From: [REDACTED]
To: [Hinckley SRFI](#)
Subject: Hinckley National Rail Freight Interchange (TR050007)
Date: 03 February 2025 14:35:23

I wish to forward my views on the above proposed project.
Hinckley Freight Interchange.

Interested party number 20038882

**Figure 1: Morning Peak Hour Queues**

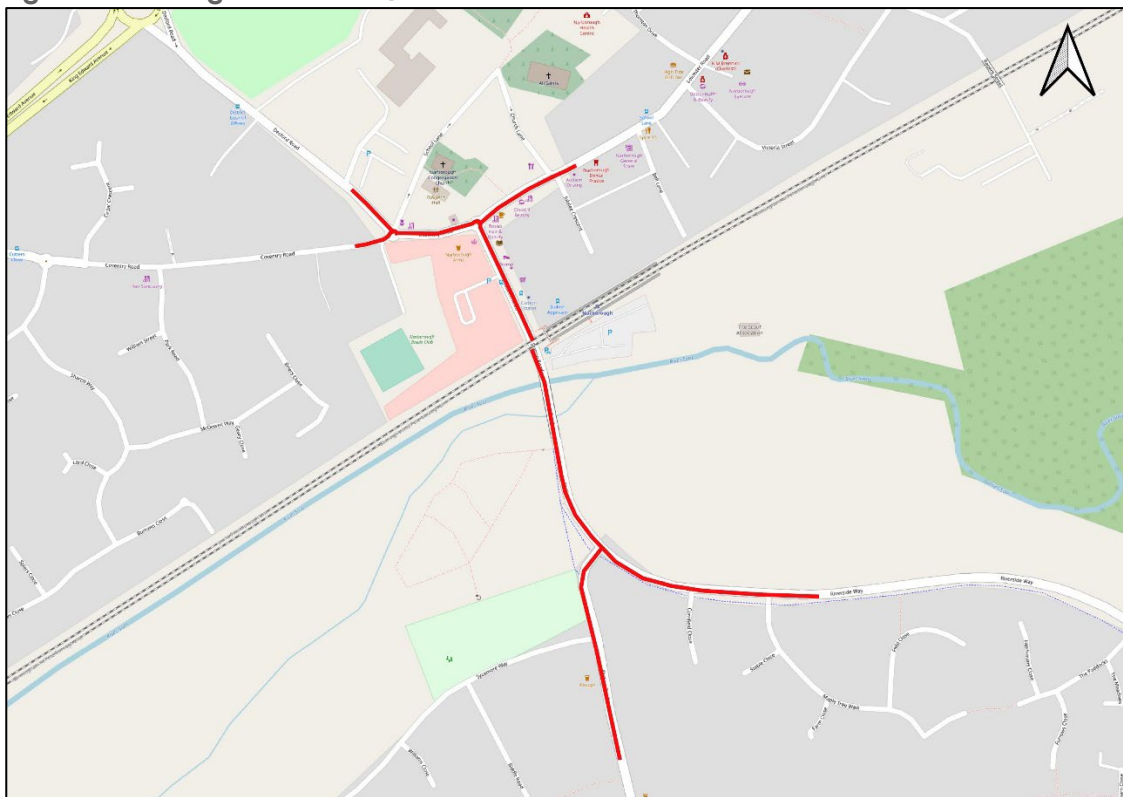
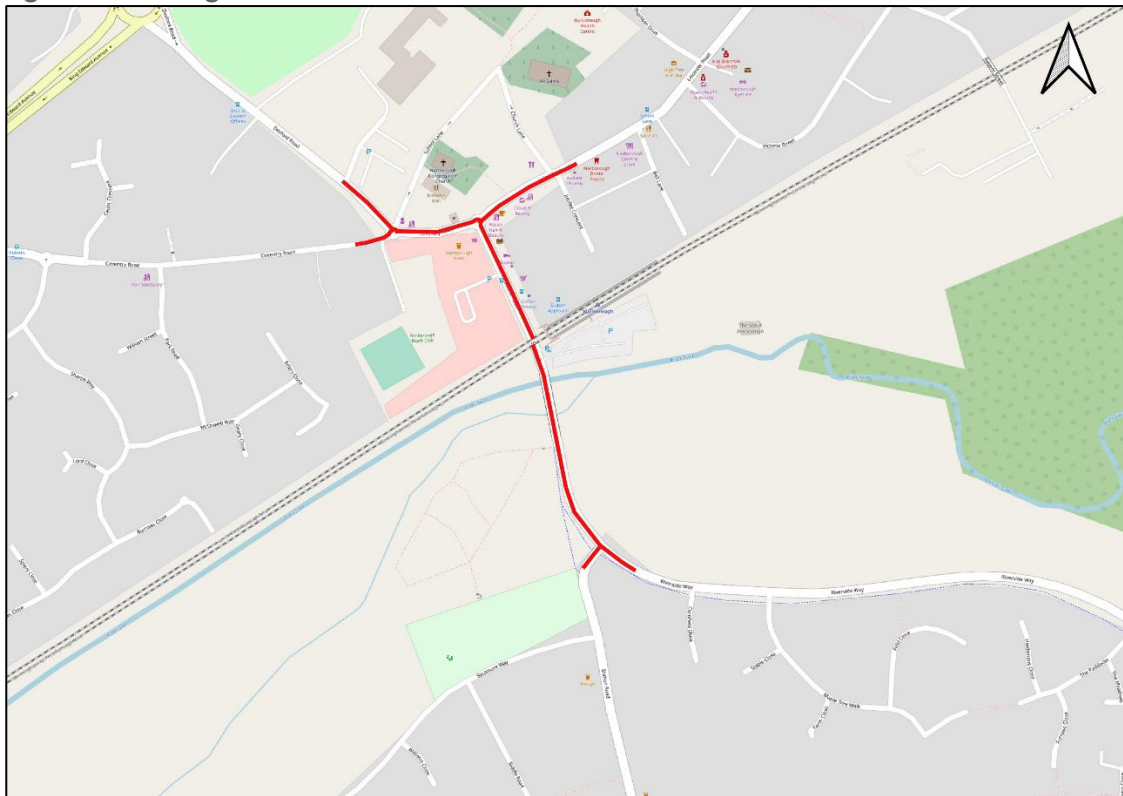
I find the response of Syntax to these concerns quite unrealistic and I also question why the problems associated with Narborough crossing have only been given more consideration after they submitted the original application? The timings and data are hypothetical and idealistic, to create a false impression about how much the quality of life for residents will be severely impacted. Their assessment of the impact on the village has been very poorly carried out and it is obvious that they conducted the study within a close proximity of the station and failed to see how far the traffic queues throughout the whole village centre when the barriers are down.

Syntax appear to be completely oblivious to how the villages of Narborough and Littlethorpe become gridlocked when the barriers are down. Usually when the barriers are down, the traffic queues as far back as the B4114, the main dual carriageway from Leicester to the A5 and this problem would be further exacerbated if this freight interchange were to go ahead. Their claims that the freight train will only add 2minutes 32 seconds to the barrier time are not based on fact, are idealistic and rely on the best-case scenario assuming all the trains will run on time and there will not be train times overlapping. Although only one train per hour stops at the station there are other passenger and freight trains which pass through the station every hour causing the barriers to be lowered and adding to the down time. When part of the HS2 contract was cancelled, it was announced by the previous government that there would be an increase in trains operating between Leicester and Birmingham which will provide a better service for passengers but also add to the congestion problems.
